Please ask for: Sian Eggington
Email: sian.eggington@terraquest.co.uk
Telephone: 0121 2341390
Our Ref: WA/36/20/HH
Your Ref:
Date: 11th June 2020

Application for Planning Permission for Works or Extension to a Dwelling

Development: DEMOLITION OF PORCH & ERECTION OF NEW, SINGLE STOREY SIDE ADDITION, SINGLE STOREY SIDE/REAR ADDITION.

Location: Murroes Dairy Lane Walberton BN18 0PT

drawing no: 1b

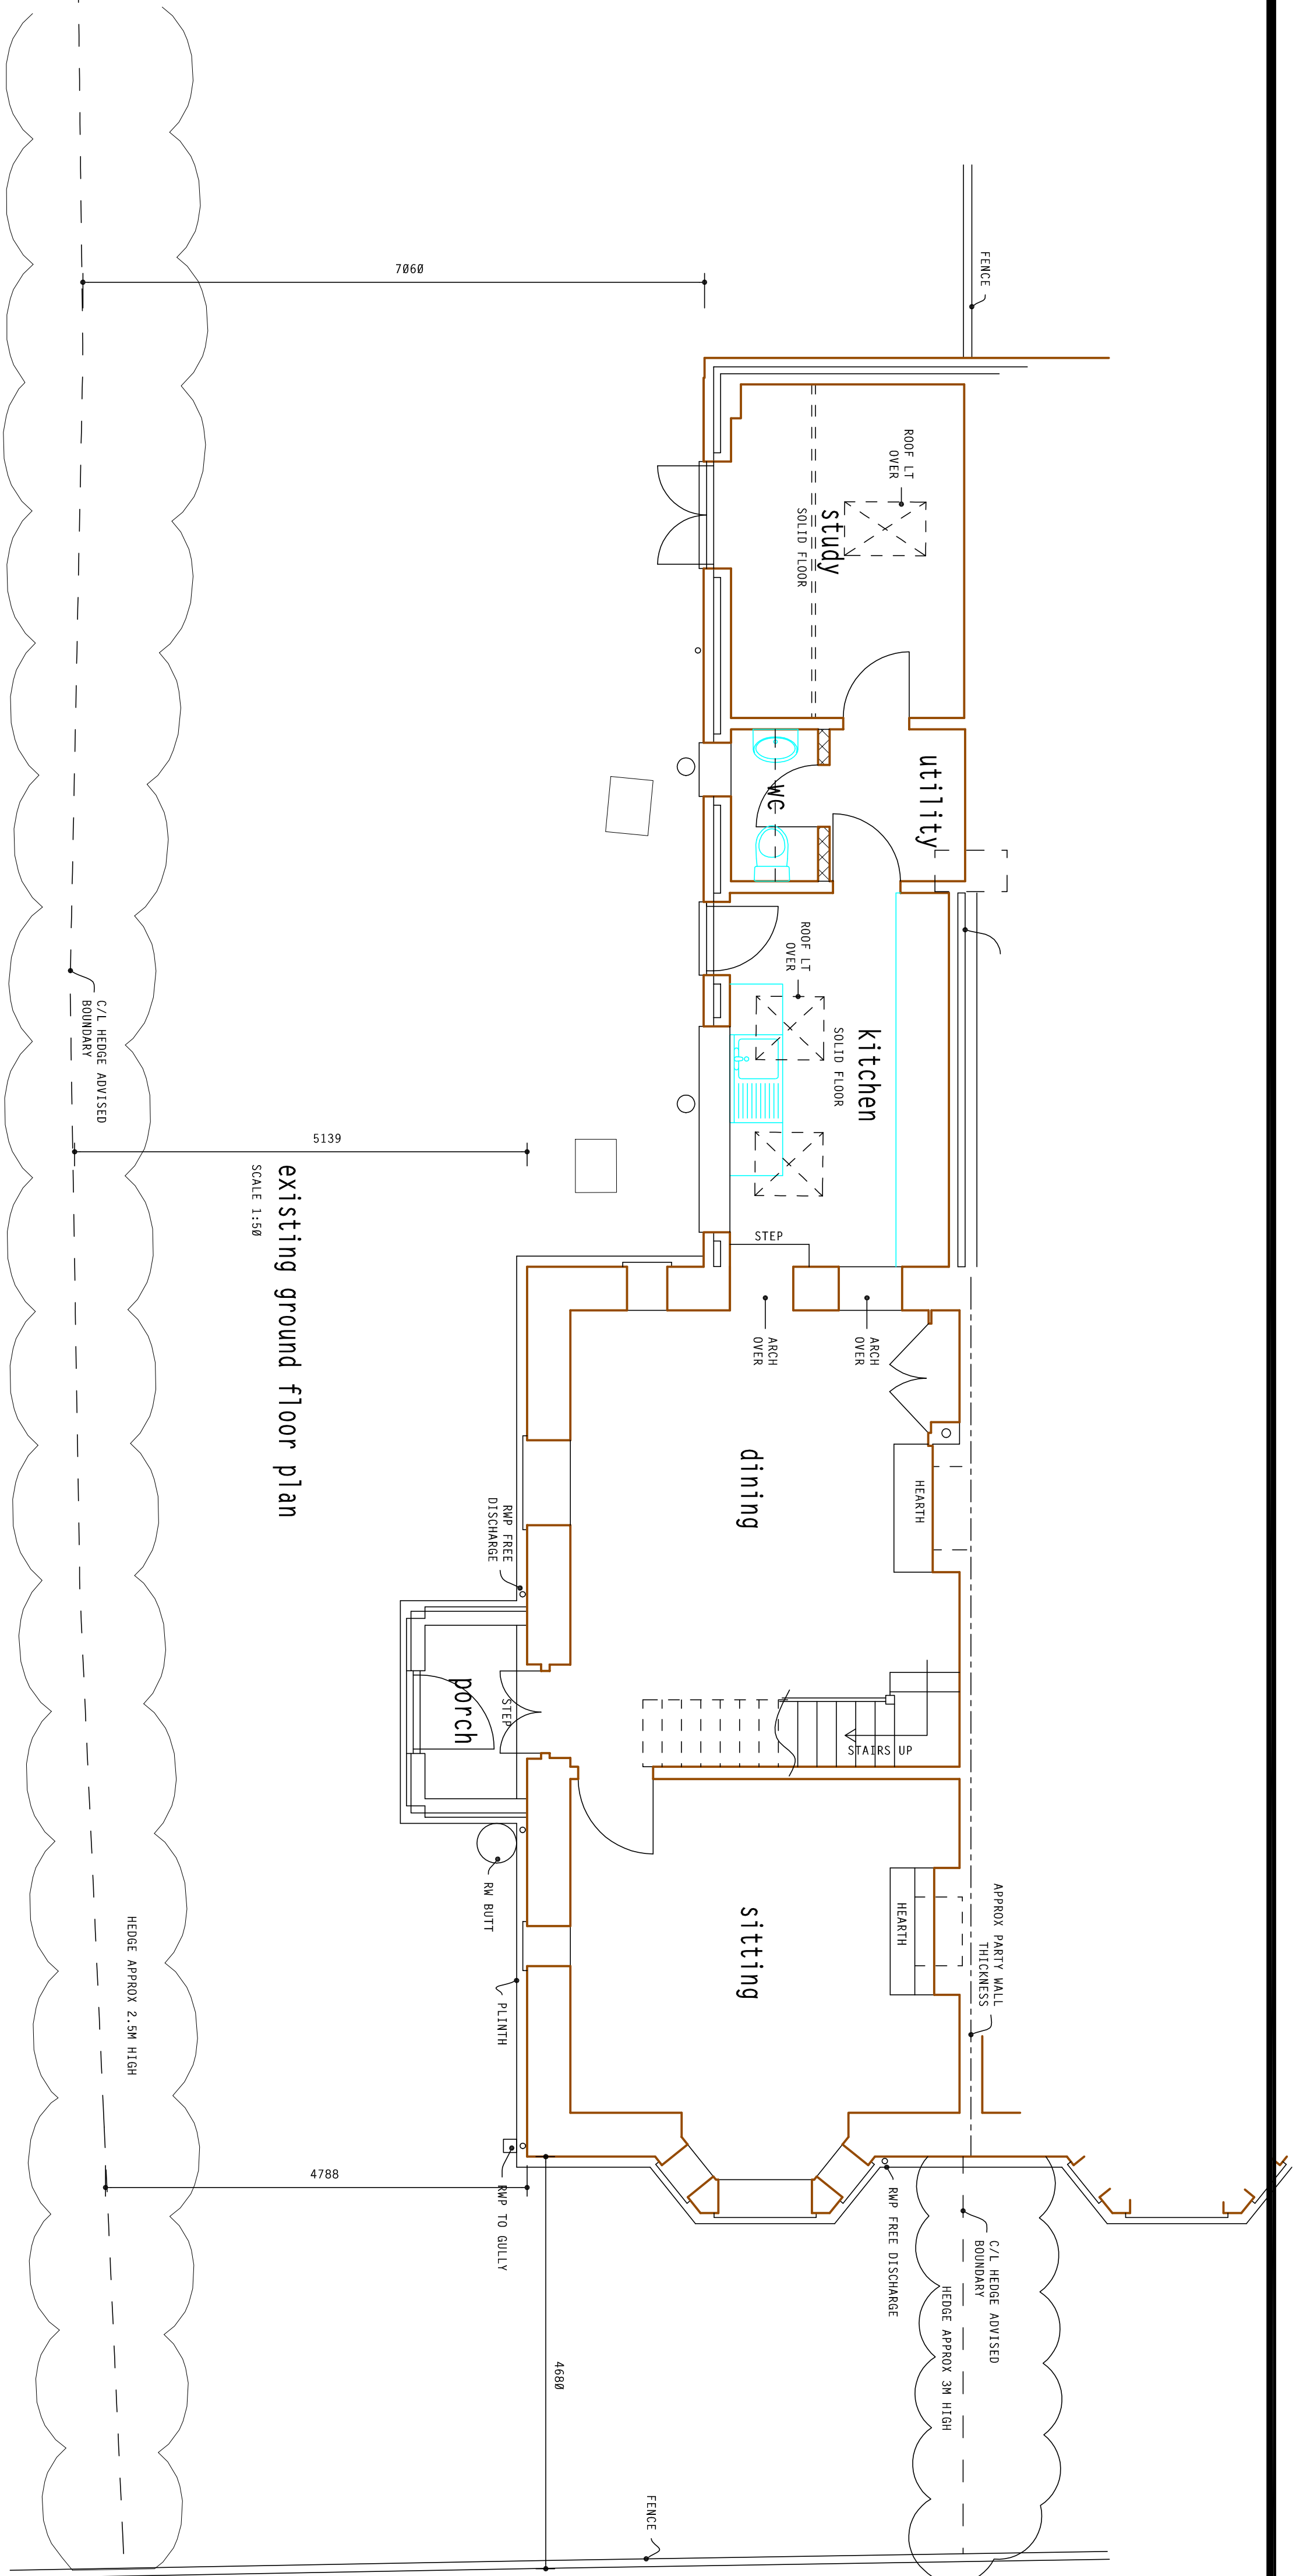
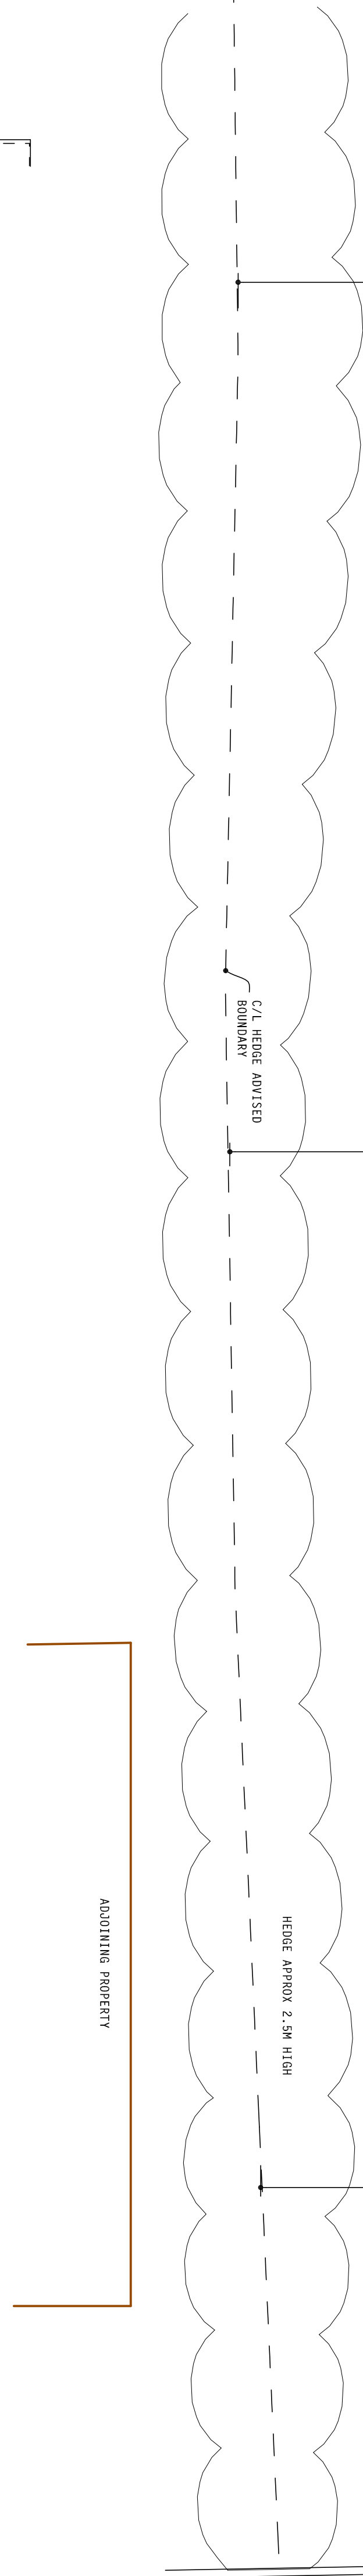
Block Plan: You are required to include the dimensions from the proposed extension to the site boundaries on the block plan.
